PORTLAND MAINE

December 13, 2007

RE: 83 West Street – 063 B007 – R-4 – setbacks and lot coverage – permit #07-1487

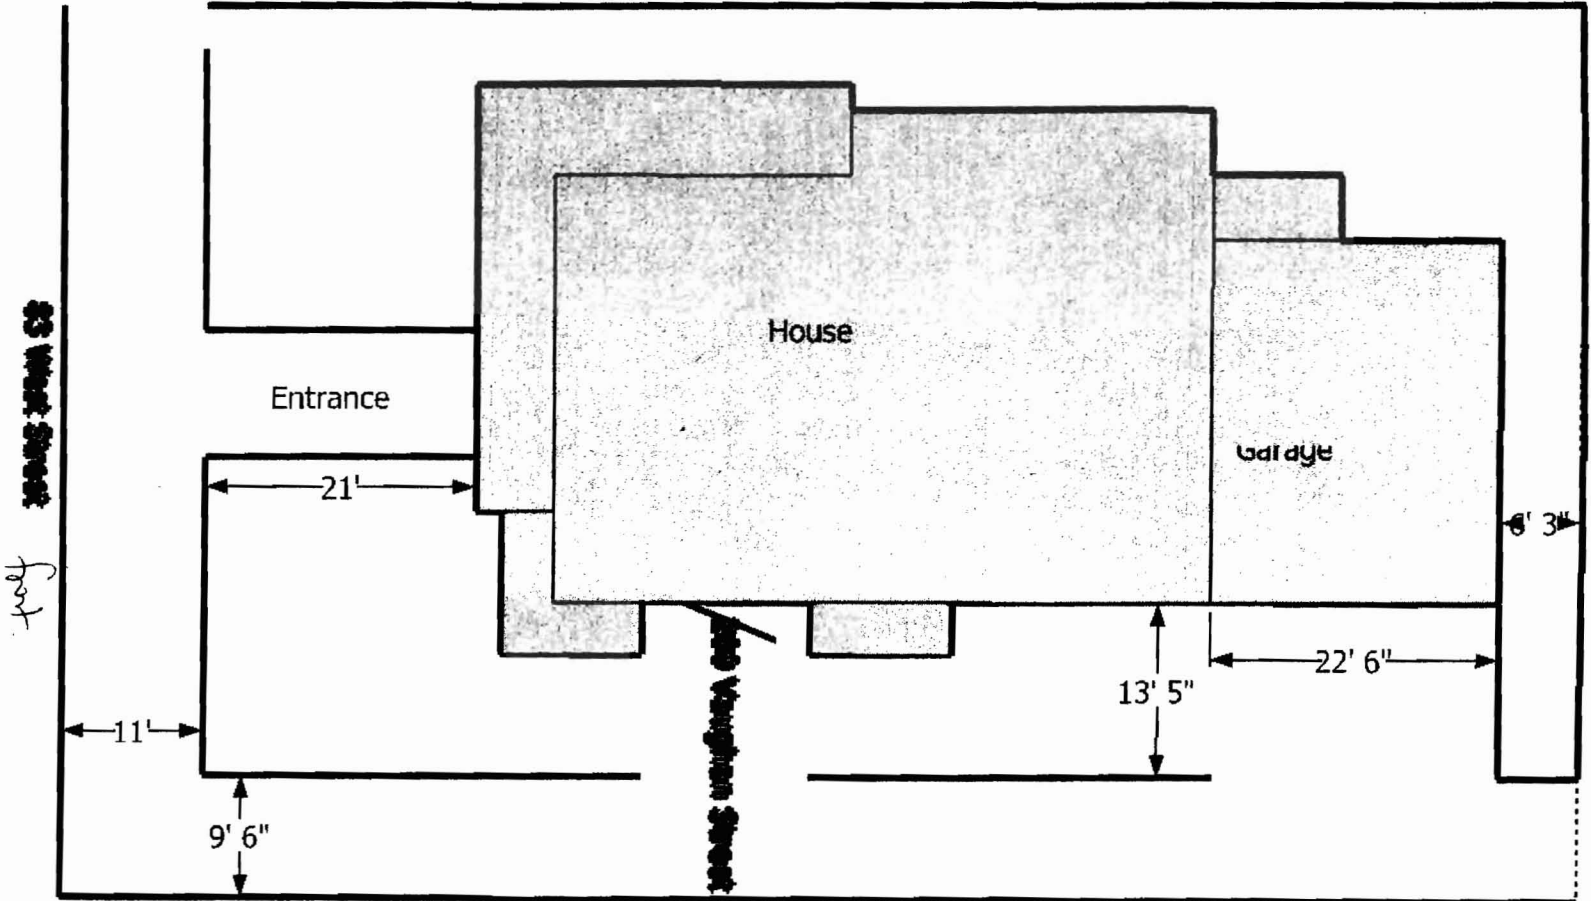
Your application to enlarge your existing garage at 83 West Street does not meet all of the requirements of the R-4 residential zone. Section 14-105(d)(2) of the ordinance states the minimum rear setback to be twenty-five feet. Your plot plan gives the rear setback to the proposed addition as six feet, three inches. This is eighteen feet, nine inches less than the required rear setback. Section 14-105(d)(4) of the ordinance states the minimum side setback on a side street to be twenty feet. Your plot plan gives the distance from the sidewalk to the proposed addition as thirteen feet, five inches. This is six feet, seven inches less than the required side setback on a side street. This section does say that the side yard on a side street does not have to exceed the average depth of the front setback of the property directly abutting the property. We need more information to determine whether your setback of thirteen feet, five inches meets this average depth with the property next door. Section 14-105(e) of the ordinance states that the maximum allowable lot coverage is thirty percent of the lot area. Your lot is 5,320 square feet. Thirty percent of this is 1596 square feet. The footprint of your existing structure is 2,570 square feet, which is already 974 square feet over the maximum allowable lot coverage. Your proposed addition would add 331.5 square feet. This would make the footprint of your structure 2901.5 square feet, which is 1305.5 square feet over the maximum allowable lot coverage. Since your proposed addition to your garage is over the allowable maximum lot coverage, and it does not meet the required rear setback and may not meet the required side setback on a side street, I must deny your permit.
